Consultee response

EP/80/20/HH & EP/81/20/L

Vista Point 21 Tamarisk Way East Preston BN16 2TE

Planning and Listed building consent to convert 2 existing garages to habitable accommodation to create a new family living space and enclose the existing outdoor link from the main house to the garage to form an indoor warm/dry link with alterations to the landscaping arrangements.

Drawing number
AA-18064-GA-50-05

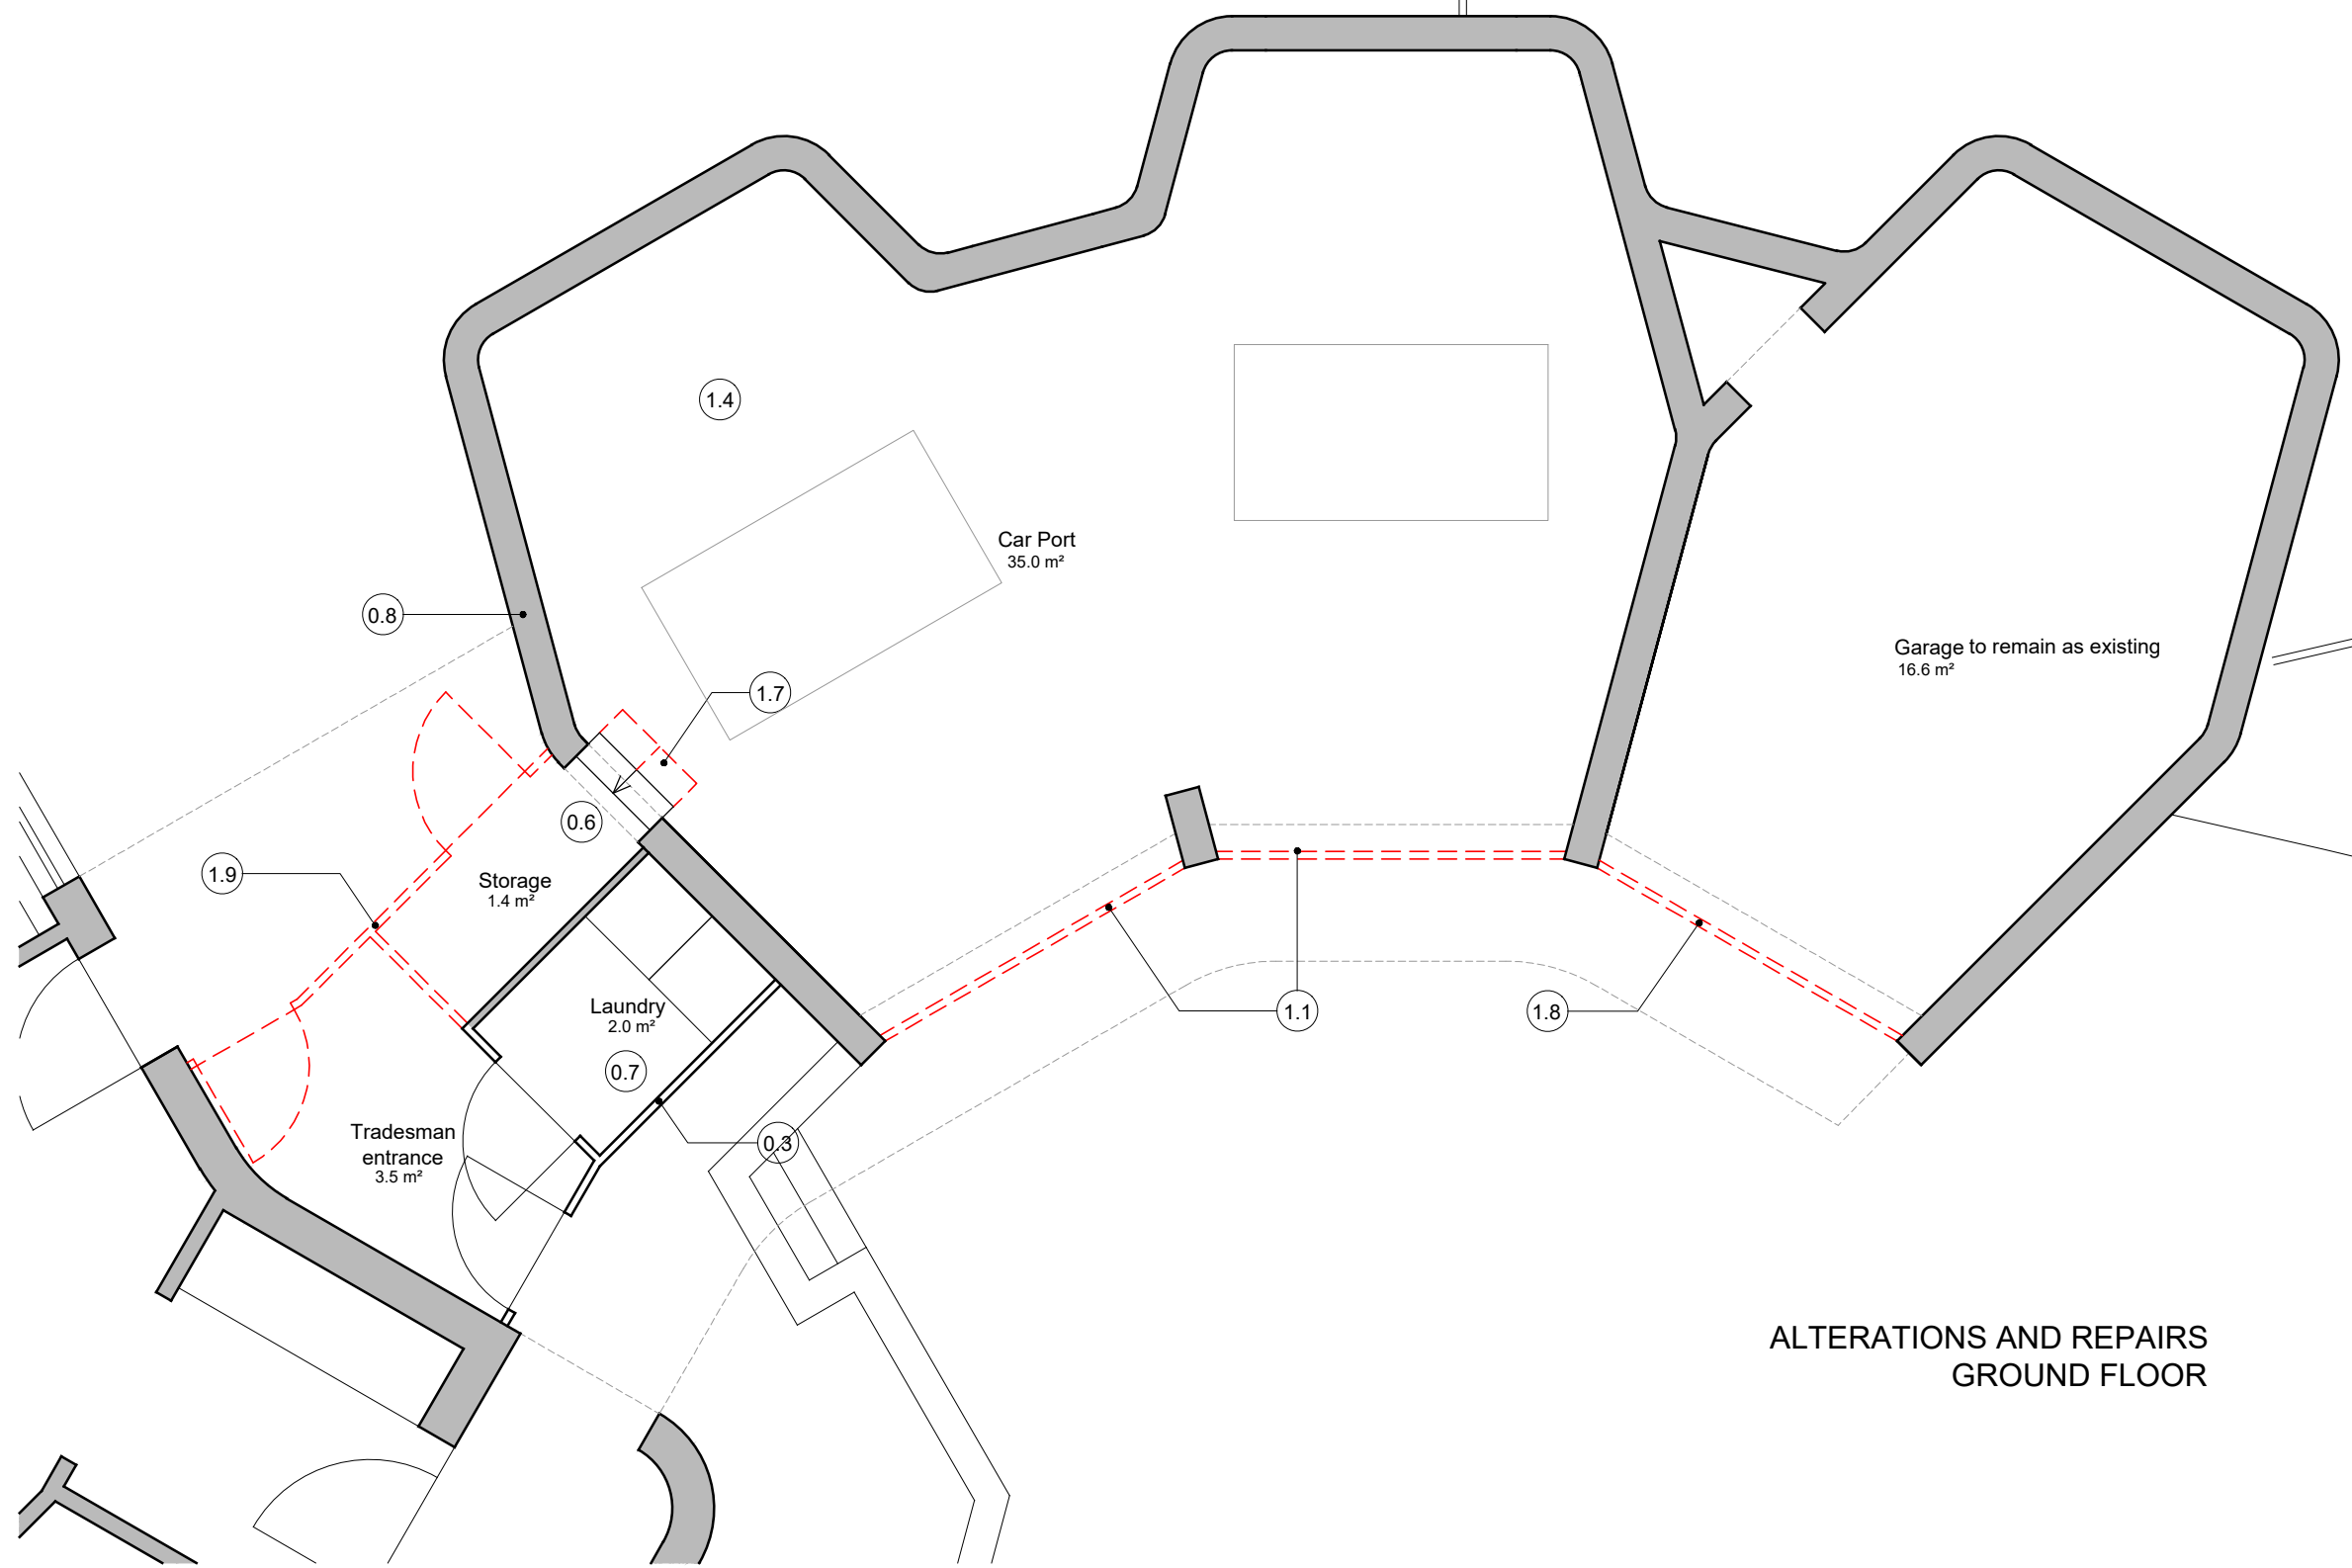
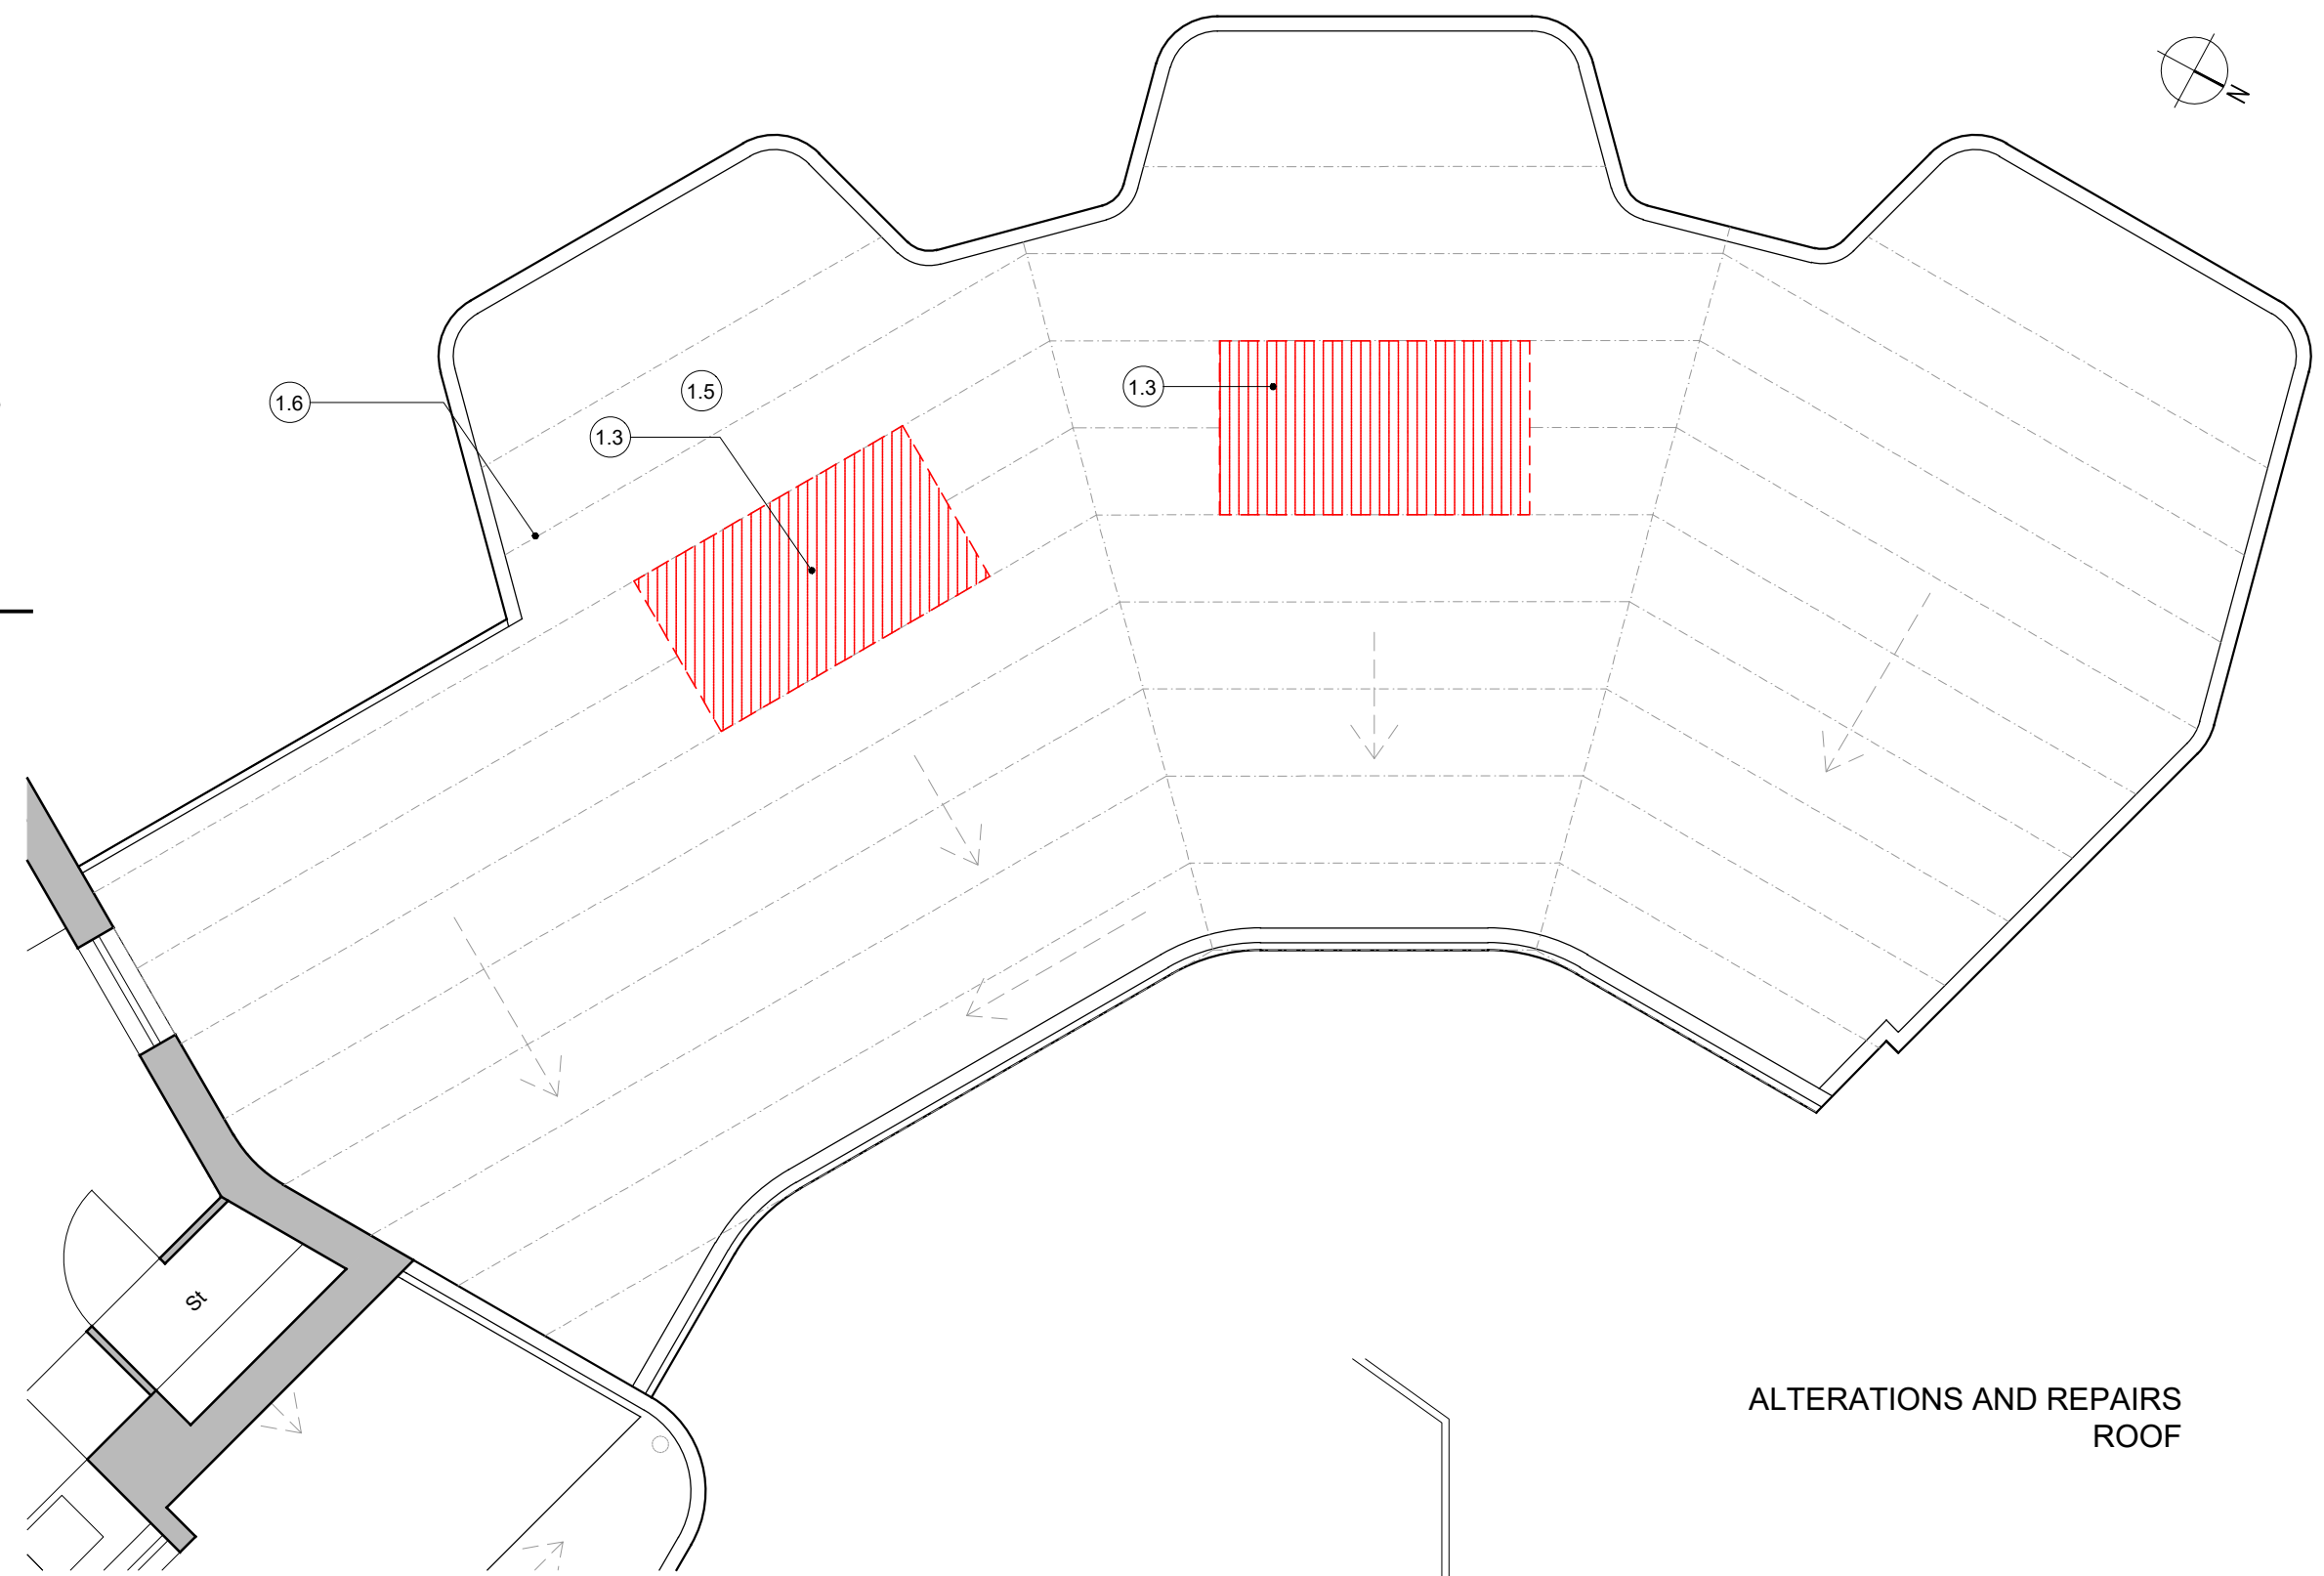
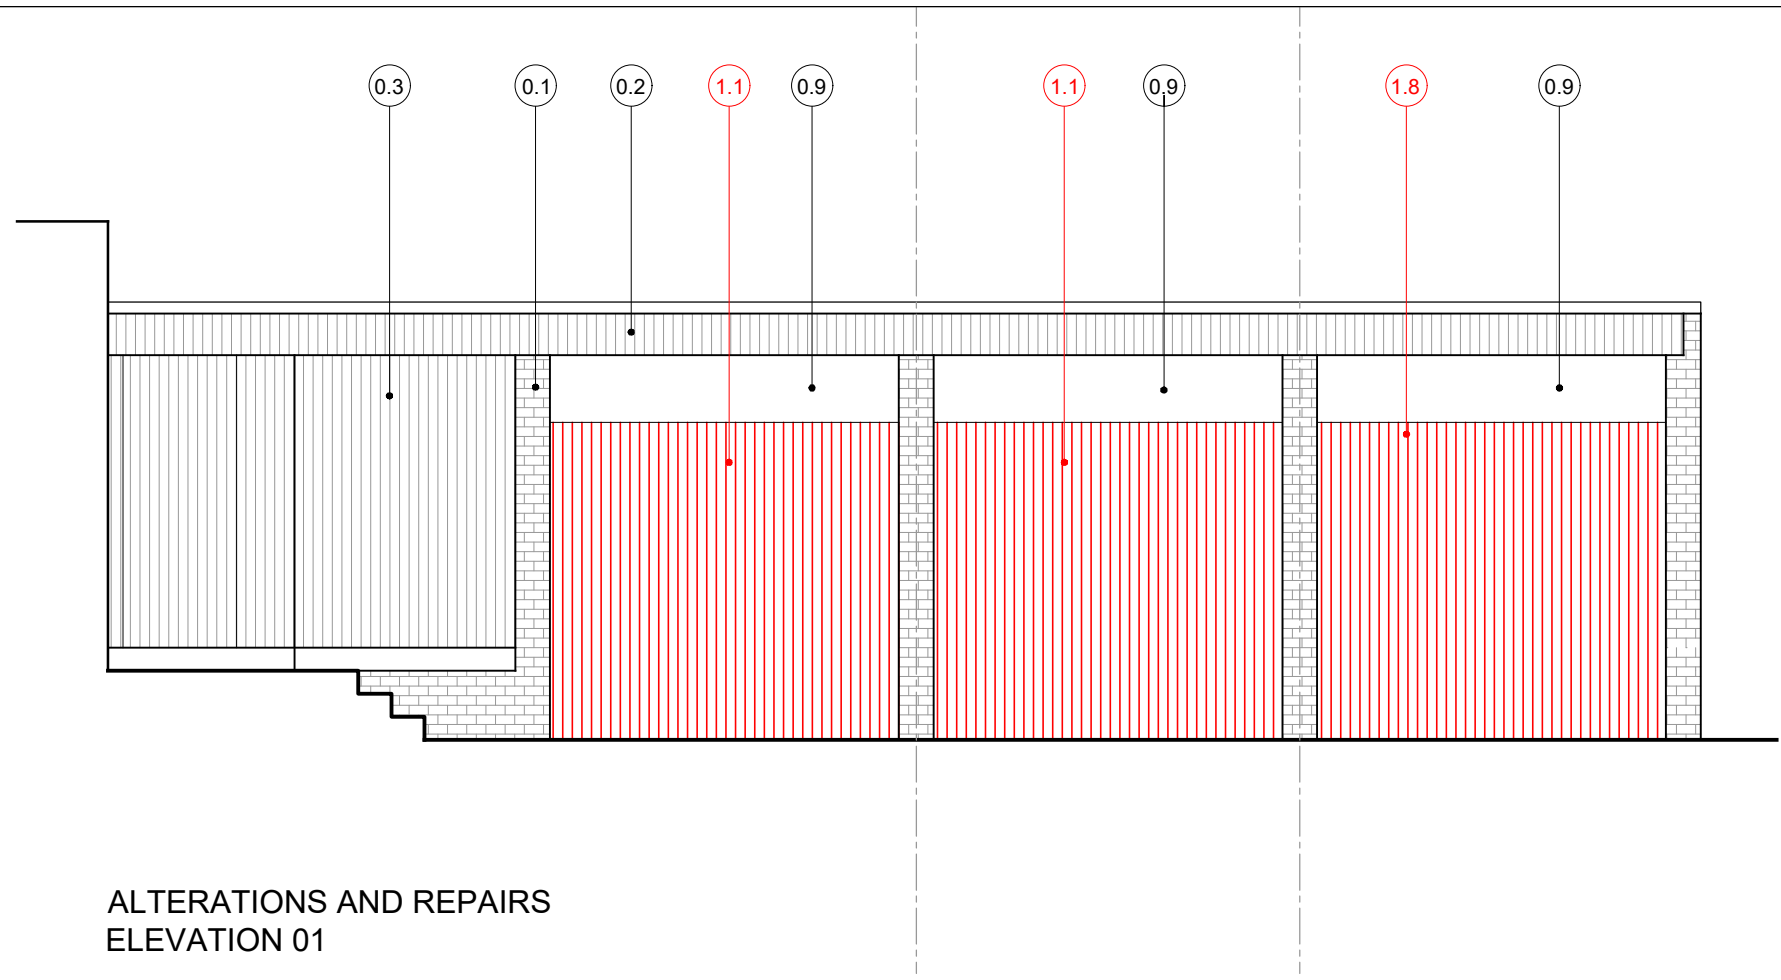
It is interesting to note on the plans proved that the original garage door remains present (note reference 0.5: Existing original door to garage). This is helpful as it indicates what the proposed new double doors could look like for the games room element of the building. It is also not clear why the original garage door is to be replaced? Is it in a poor state of repair, and unable to be salvaged?

Justification has been made for the use of the two rooflights (provide light when the doors are closed and no openings on the rear elevation), which if successfully, and carefully designed will, on balance, be acceptable. This is subject to a detailed design being approved by way of condition.

It would appear that the intention is to install new aluminium double glazed screens (item 3.1) behind the new double doors (item 3.5) of the games room. This is acceptable as it is a suitable method of providing light into the space when in use, whilst at the same time hiding the interior away from use when not. Details of the windows and doors should be provided for by way of condition, if you are minded to approve the application.

It is also noted in item 2.3 to 'Allow for ventilation between existing timber joists by installing grills in external walls. Subject to Heritage approval'. Details of this will be required in order to understand the impact that they will have on the building and the historic fabric.
